Our ref: 09/170-09

3 November 2015

**RE: Orica Southlands Remediation & Warehouse Development Project -
Proposed Modification 3 (MP 06_091 MOD3)**

PROJECT
PORT BOTANY INDUSTRIAL ESTATE
McPHERSON STREET, BOTANY, NSW, 2019.
TITLE
SITE PLAN

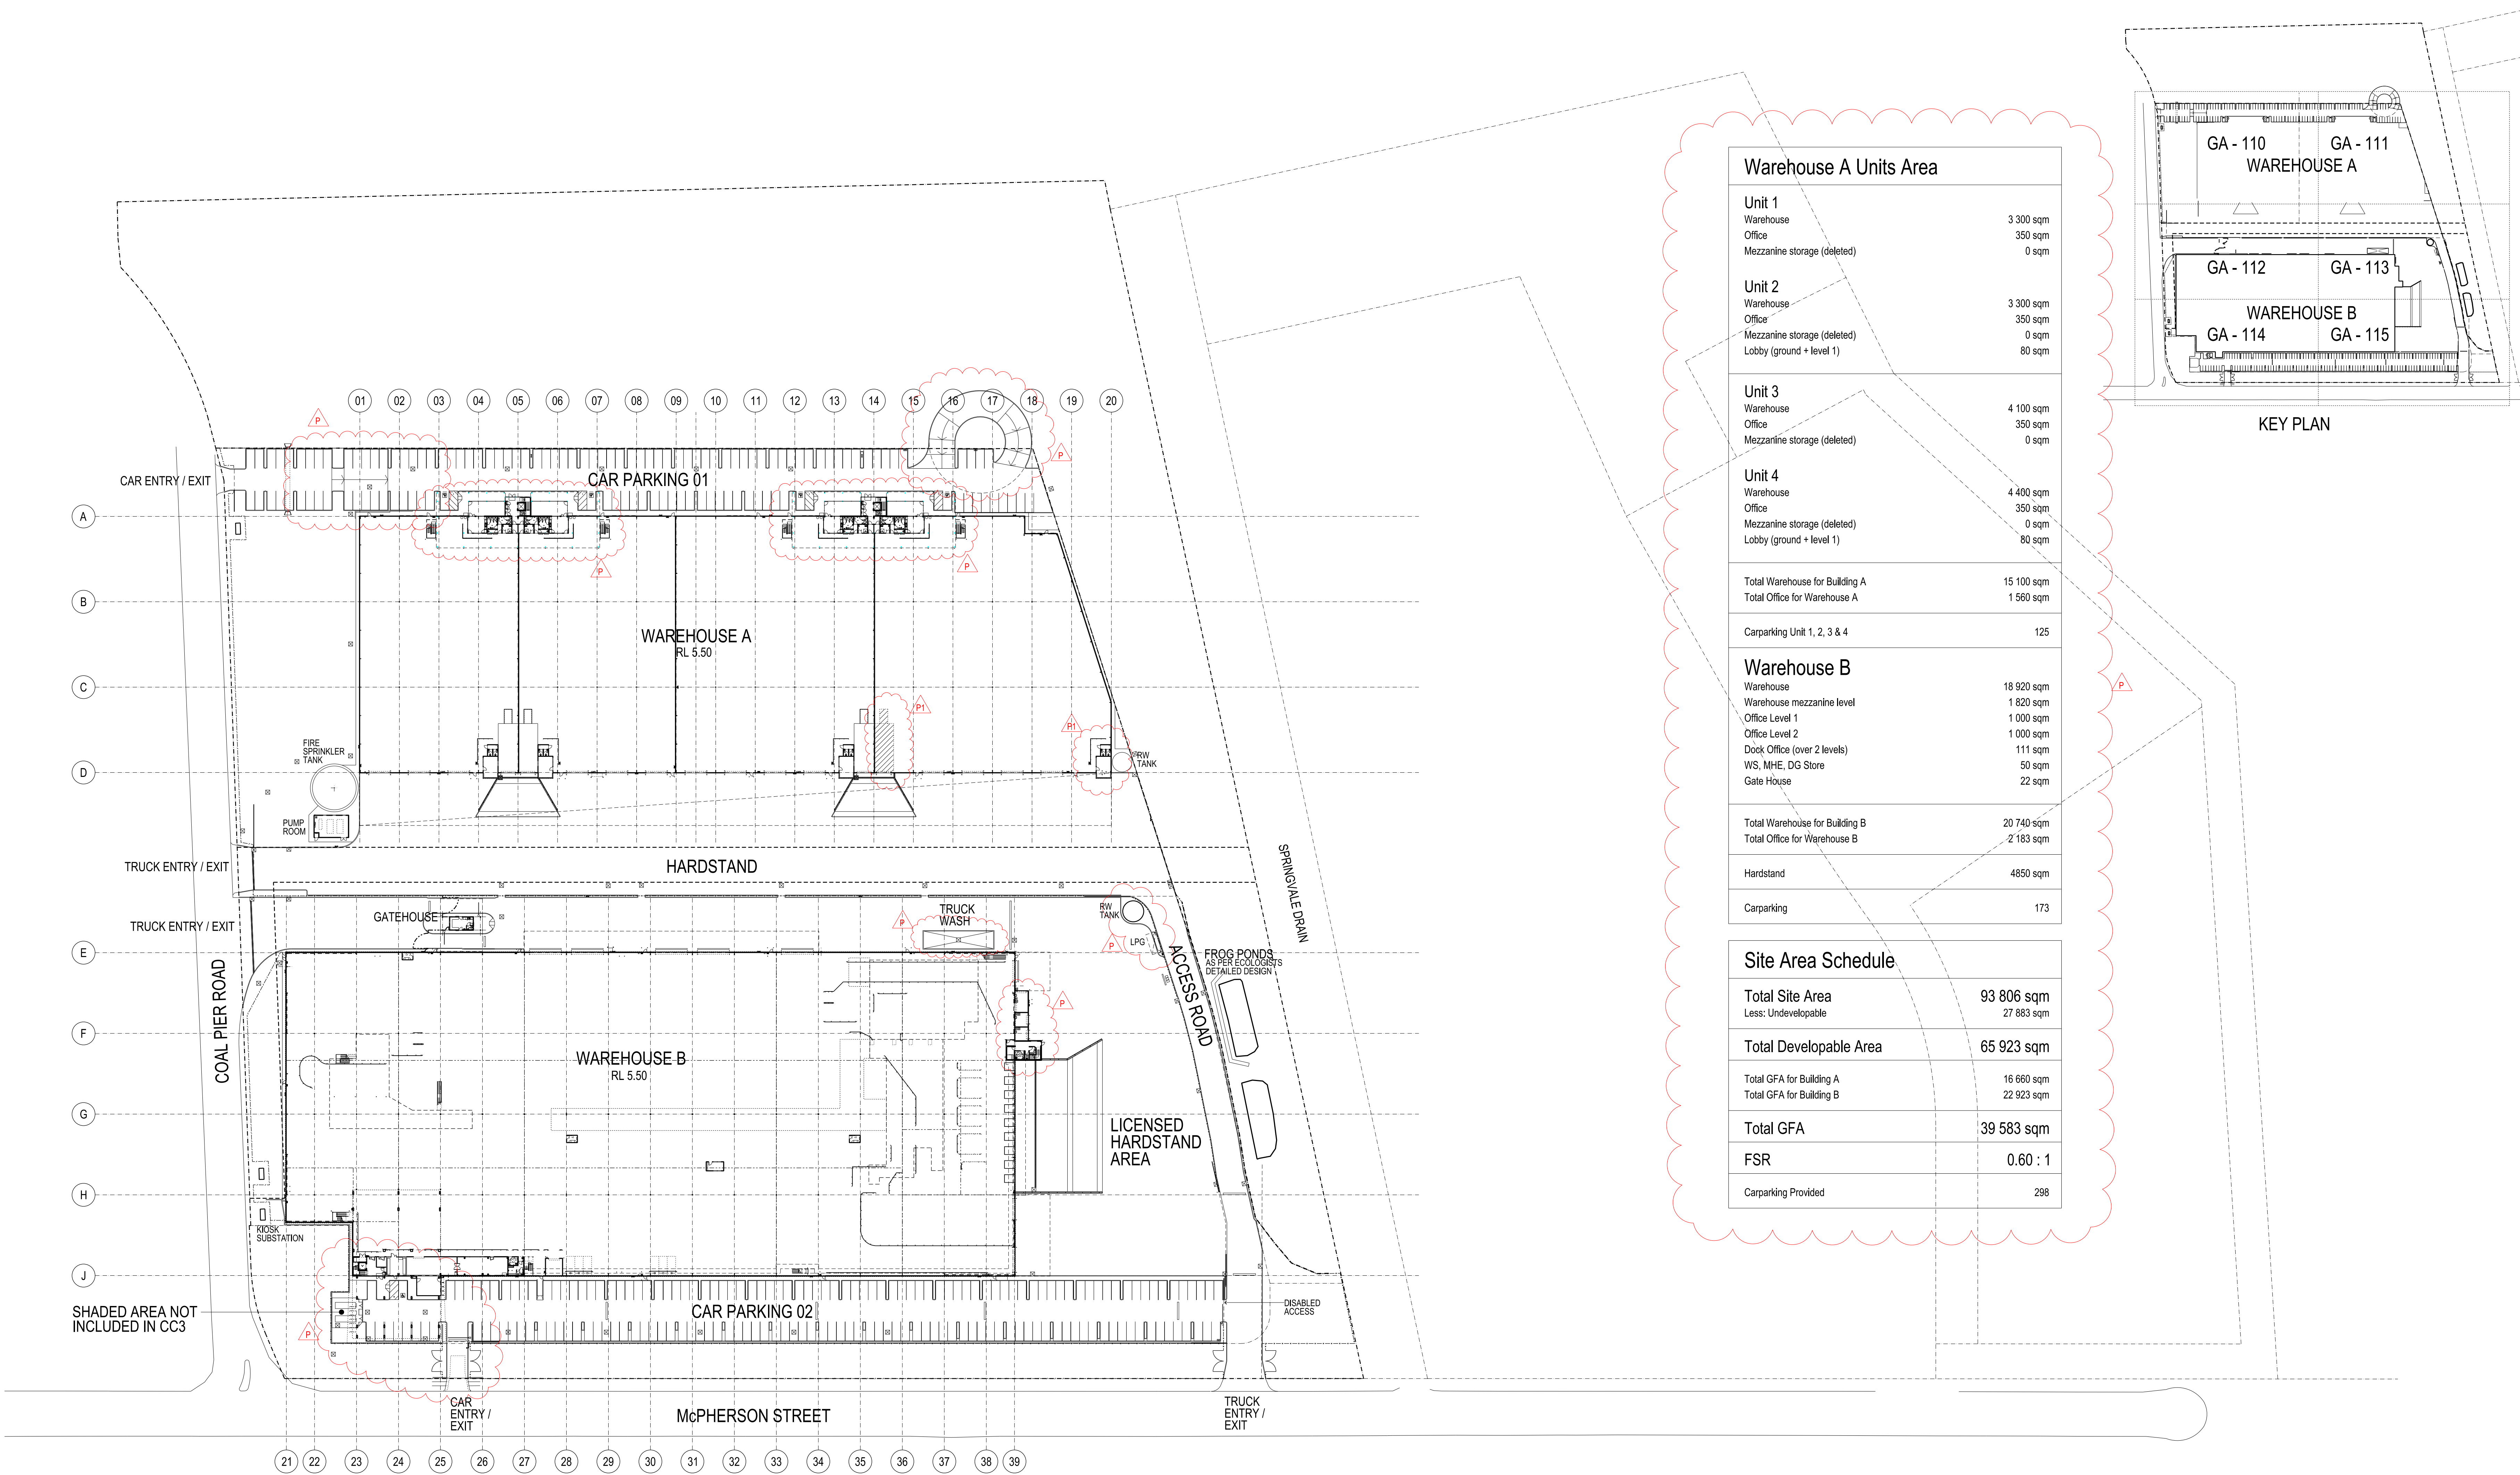
Car Parking - Council has no objection to the proposed reconfiguration of the car park. However, the car park area should be appropriate landscape in accordance to the requirements of the previous approval.

Turning Head - Council's Traffic Engineer indicated that the turning head is to have a minimum radius of 12.5 m and ideally 13.0 m for emergency and garbage trucks.

WHA GROUND FLOOR PLAN PART 01

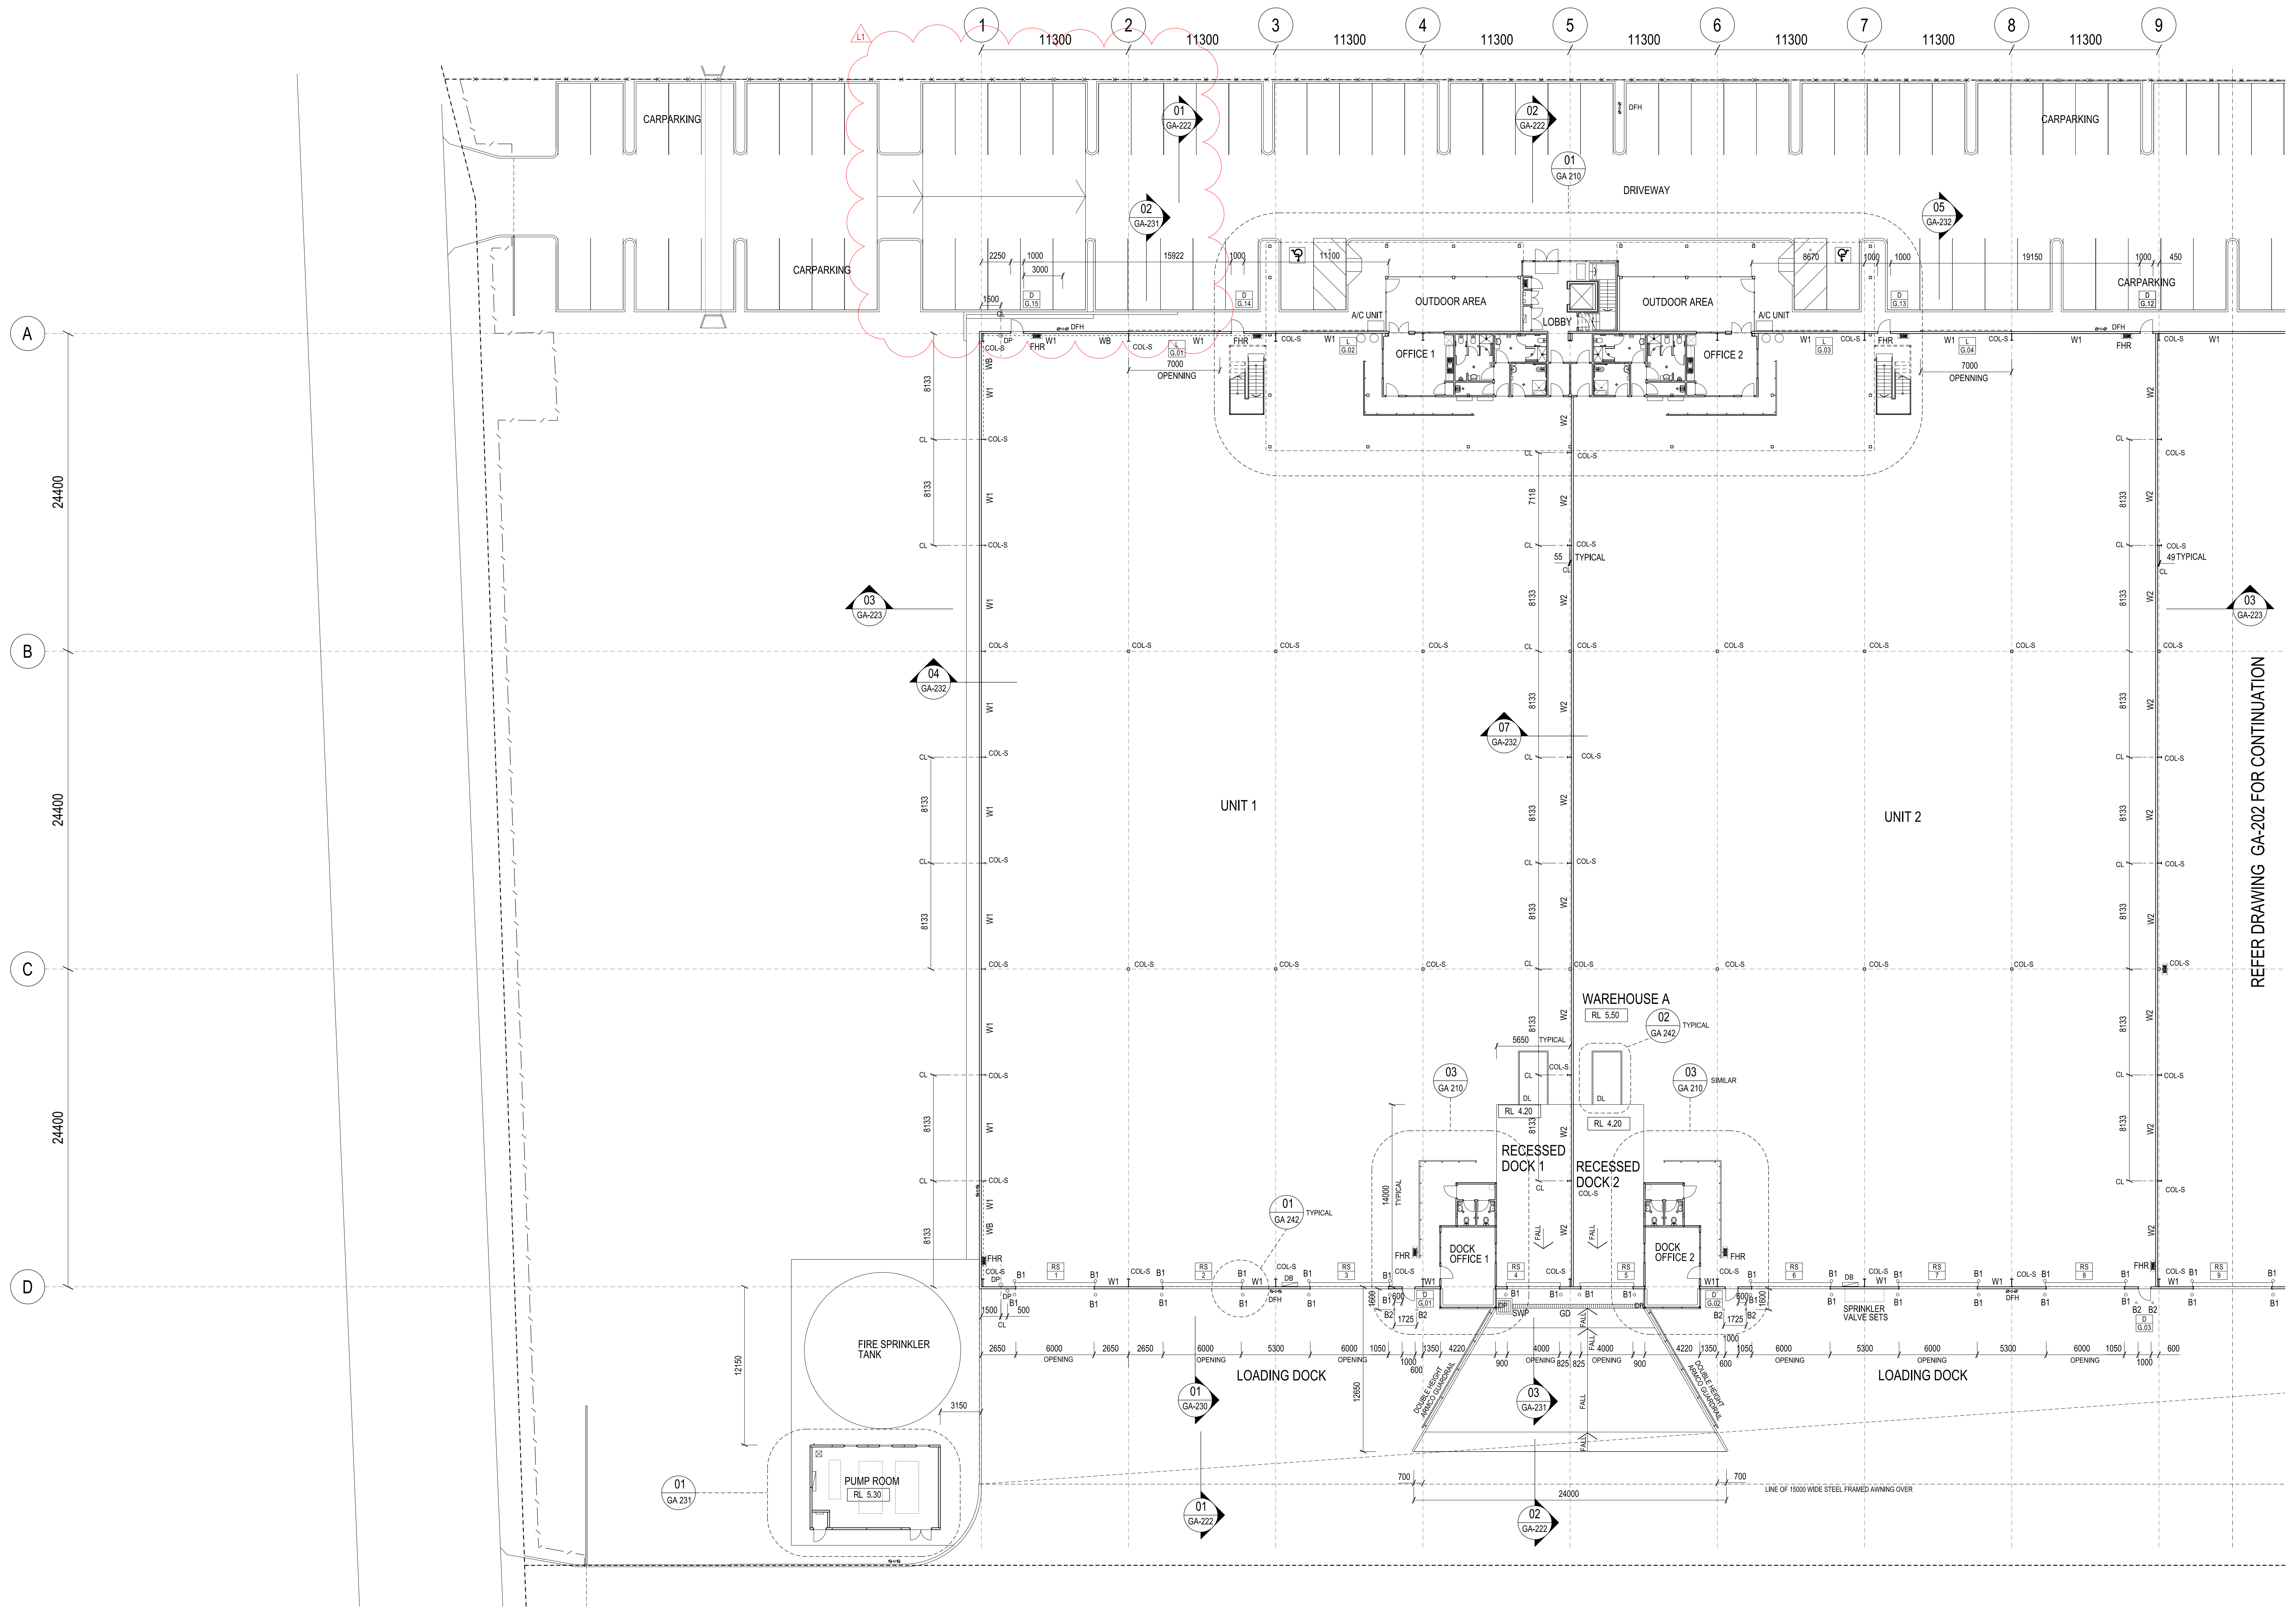
GFA - The table contained in Page 4 and 5 of the EIS (prepared by Goodman) indicated that each of the approved offices has a gross floor area of 604sqm (Unit 1, 2, 3 & 4 in Warehouse A). This appears to be incorrect as the approved architectural plan (4244_DA-01) indicated that each of the approved offices has a gross floor area of 350sqm. The EIS is to be updated prior to development approval.

Mezzanine Storage Area – Page 7 of the EIS (prepared by Goodman) stated that removal of the mezzanine storage area will result in a reduction of 964sqm of GFA. This is incorrect as the Mezzanine Storage Area for Warehouse A only has a gross floor area of 428sqm. The EIS is to be updated accordingly.
